### **Planning Application 3/2016/0763 - 1 Tithe Barn Cottage, Pendleton Road, Wiswell, BB7 9BZ**

Wiswell Parish Council have considered the above application for a proposed replacement garage and would like to make the following comments:

The application is for: Proposed replacement garage

Proposed Garage Plan and Elevations

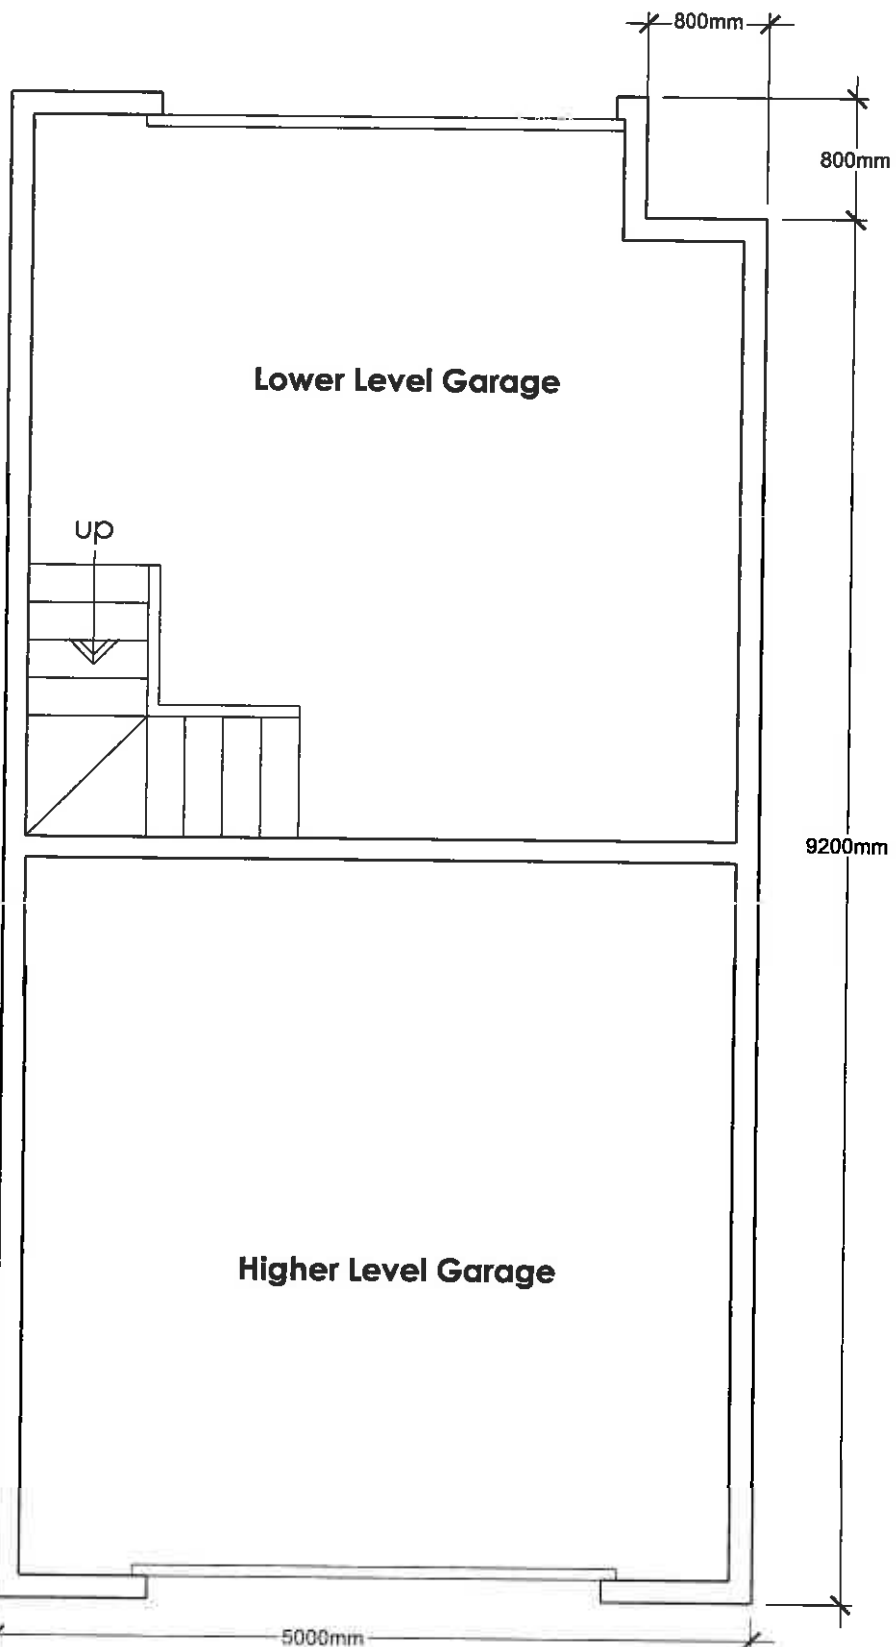
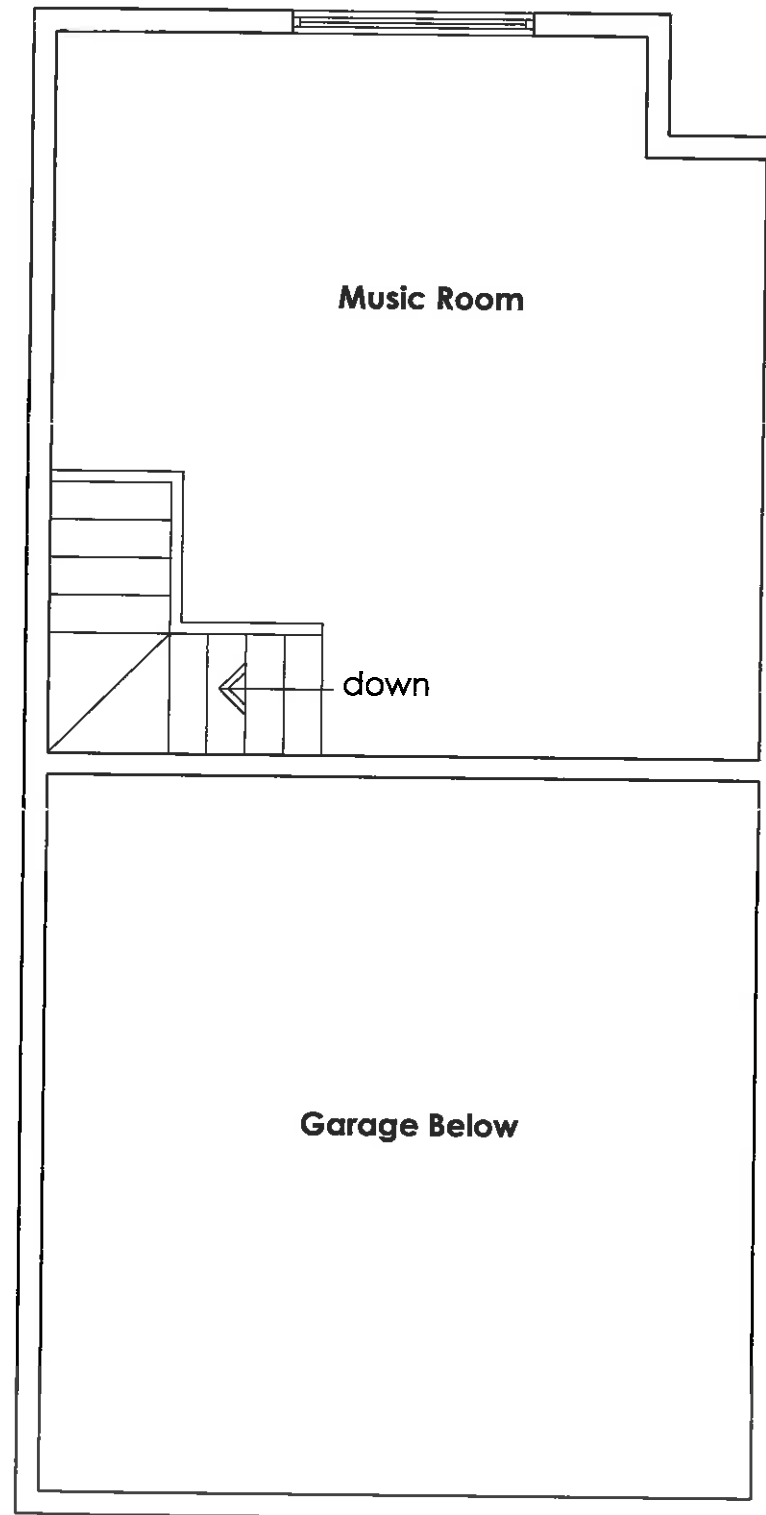
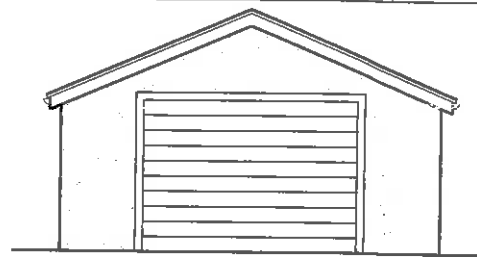
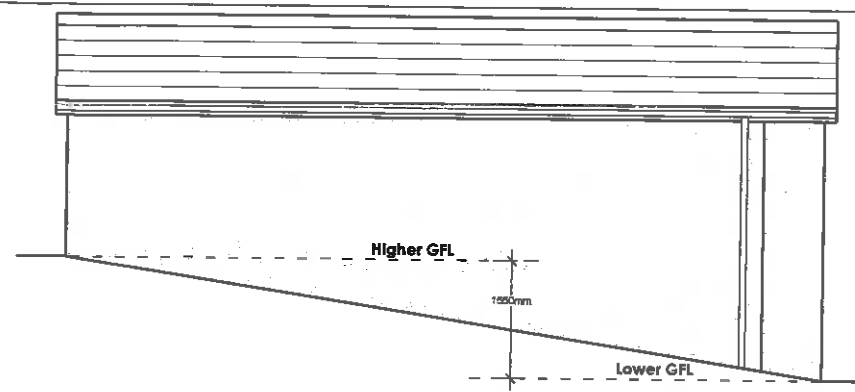
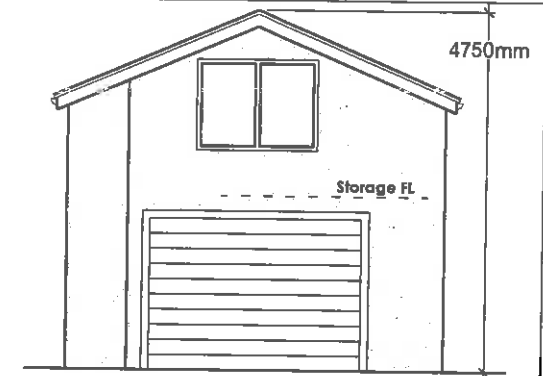
1. The replacement garage is welcomed as the existing building is in need of some repair.
2. If approved, the garage must only be used for the purpose intended. It is understood that the owner is a building contractor and the garage should not be used for any trade or commercial purposes relating to this or any other business activity, or as living accommodation.
3. In order to protect neighbours' privacy, no windows should be erected overlooking adjacent properties.
4. In order to protect residential amenity, there must be soundproofing for the area designated as a music room.
5. The concept of a higher and lower garage is very unusual. It appears that both garages will be short and the dividing wall is not dimensioned. There are no details of how the lower garage will be accessed and this should be clarified.
